Subject: A585 Windy Harbour to Skippool Improvement Scheme

Your reference TR010035

Submission to the Planning Inspectorate 7 October 2019

A585 Windy Harbour to Skippool Improvement Scheme

Figure 6: Flood Zones

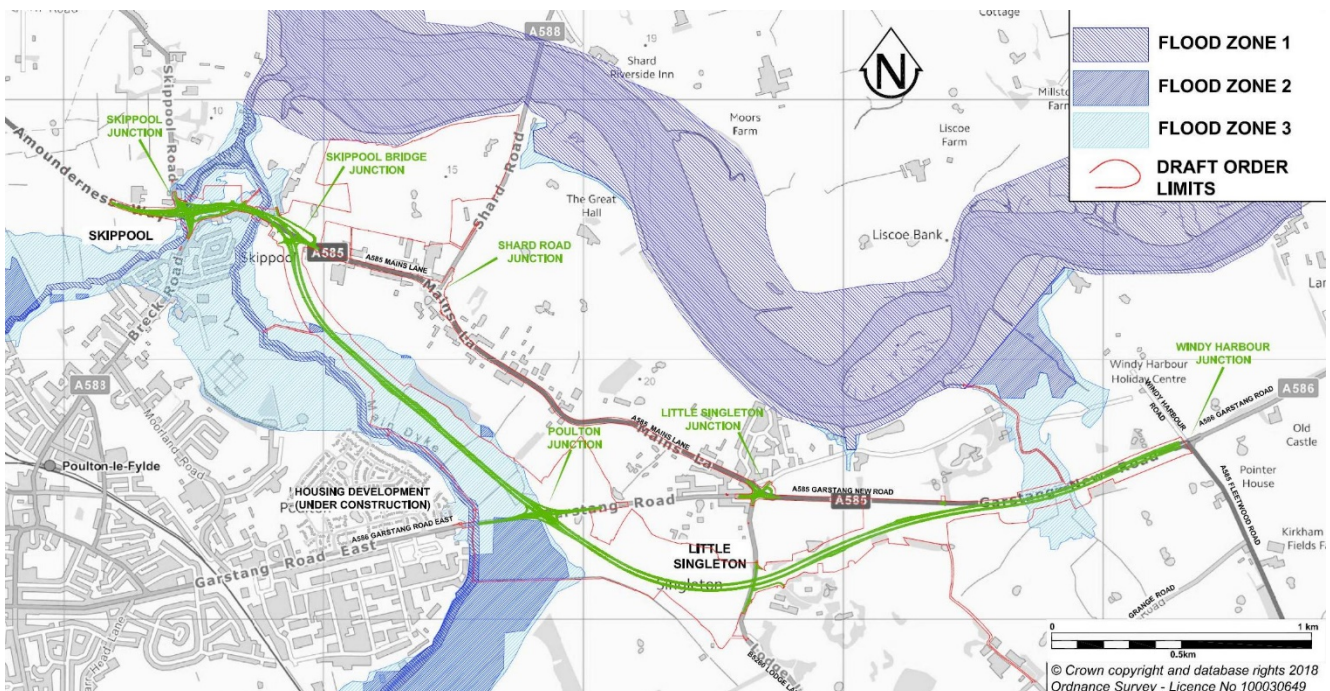
It is not clear how it will prevent flood water taking its normal path across Thornton Lodge car park and onto Skippool Road. If the tide is increased by a tidal surge it could be high enough to flood Skippool Junction.

We have made several attempts to establish the predicted height used in the Flood Risk Assessment on (FRA) during a 1 in 200 year storm on the River Wyre but these details cannot be disclosed by Highways England. However, an analysis of storm surge data indicates that this year the tide height could be 7m AOD which would flood Skippool Junction and its surrounding houses.

It is remarkable that the formula used in the FRA to calculate flood depth at Skippool after a 100 years of rising sea levels produces a tide height similar to the level that can occur today whilst the same tides will inundate large areas of Thornton, Cleveleys and Fleetwood.

The FRA states that in 100 years tide heights will increase by 1.25m and the road at Skippool will flood to a depth of 100mm. This level of flooding will occur during Mean High Water–Springs (4.4m AOD) and protection against Higher Astronomical Tides (5.3 to 5.9m AOD) would be achieved by building a dwarf wall above Horsebridge Dyke. These estimations are misleading because they exclude tidal surges.

During a 1 in 200 year storm, a tidal surge of over 2m can take place during a 5m AOD Spring Tide. Allowing what is now considered to be the minimum sea level rise of 1.25m, flood water on the road at Skippool would be 8.25m AOD. The water on the road at Skippool would not be 100mm deep, but almost 2 metres.

It has been estimated that sea levels could rise by over 0.5m in fifty years. There are now over thirty 5m AOD tides each year and when one occurs during a 1.0m tidal surge the dwarf wall will be overtopped. Storm surges can last for days and when they occur during a series of high tides the only road from the M55 will be flooded for several days at Windy Harbour and Skippool.
